From: 
Sent: 21 January 2021 20:19
To: Planning
Subject: Objection to Planning Application No. 3/2020/1015

In regards to Planning Application Number: 3/2020/1015 at:

**Inglemead
Waddington Road
Clitheroe
BB7 2HN**

Drawing No. A200 Revision A

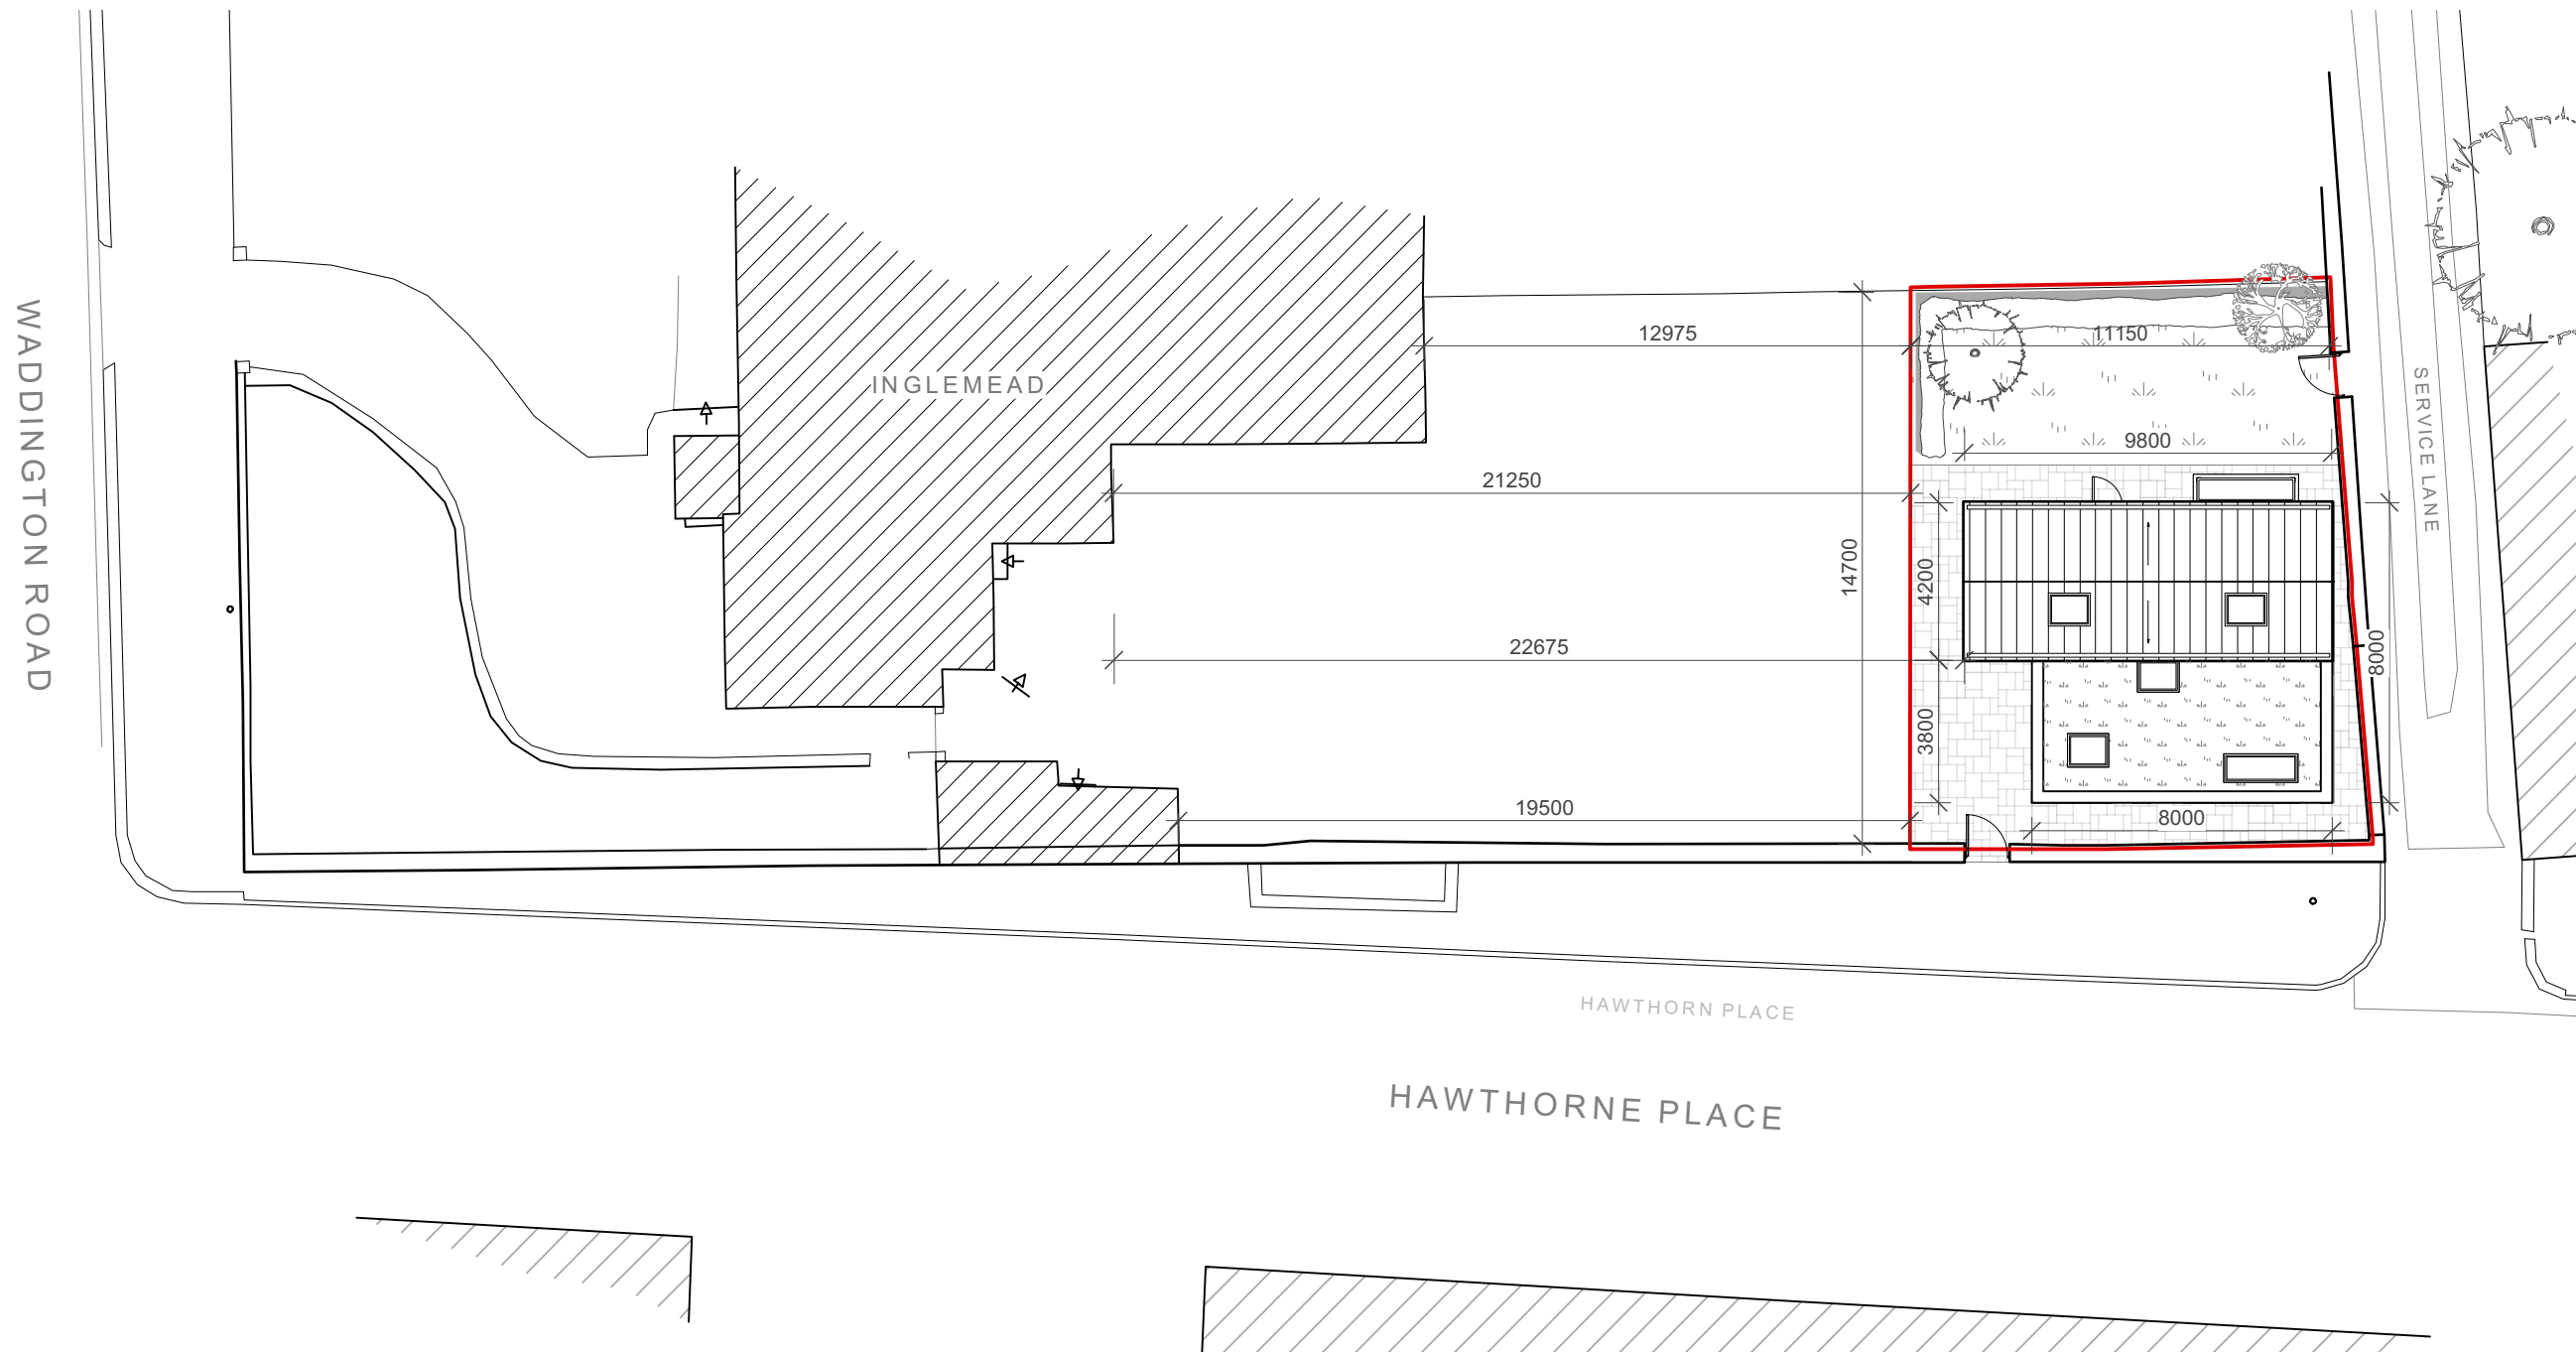
We object to the development plans at Inglemead on the grounds that there is a current lack of parking on Hawthorne Place and the access from Hawthorne Place should not be allowed. Currently, there is not any assigned parking or off street parking for the first row of terraced housing and the semi detached houses up to number 16. Is it fair to assign a parking spot via H-Bar Marking to the new house when existing residents have to park on a first come, first serve basis? Hawthorne Place is a street filled with retired couples and young families. A driveway accessible from Hawthorne Place would increase the risk of death and injury to our vulnerable children and retired people. Any access to the property from Hawthorne Place should be denied as the concern is there will be a future variation from pedestrian access to vehicular access without consent and without penalty.

Regarding the above amended planning application , one of our objections to the original application was the proposed access on to Hawthorne Place.

Whilst we are pleased that the vehicular access point has been removed from the plans we do feel that ANY access to the proposed new dwelling from Hawthorne Place is unacceptable and unnecessary .

IF planning for the dwelling is approved it should be on the condition that access is gained from the "service lane" at the rear of Inglemeade .

Also that a stipulation is put in place that no vehicular access is allowed onto Hawthorne Place in the future due to road safety , as we note that the original parking area on the site plan is still shown .

comments: Further to the amended and resubmitted plans for the detached dwelling at the bottom of the rear garden of "Inglemead" to be accessed from Hawthorne Place, we appreciate that parking and highway safety consideration has been given with regard to access to a garage from Hawthorne Place. We note the garage access has been amended to a site entrance (1800,) however the site plan still accommodates for a "parking space" with no current or appropriate access to it. A concern for this would be that it is the intention of increasing the site entrance to accommodate for vehicle access in the future (possibly without the requirement of planning permission?). Therefore all the previous highway safety and parking concerns will be the same. As covered within our objection letter of 21 December, there is existing access to this proposed site from the service lane and can see no benefit for relocating this from one side to another, and the property would still have two access points. At the same time, keeping the side entrance on the service lane would negate the need to destroy a wall that would provide privacy to the new occupants, adjacent and opposite neighbours. Therefore we feel that a reasonable suggestion would be to keep the current access on the service lane and utilise it for access to a parking space to the site (whilst appreciating redesigning the ground floor layout for the bedrooms to the left of the site) With the increased pressures on Hawthorne Place as a whole with current building proposals, adding a further two bedroomed property at the lower end with the additional parking facilities they would require, will bottle neck and compound the parking issues on the road as a whole. Thank you for your consideration
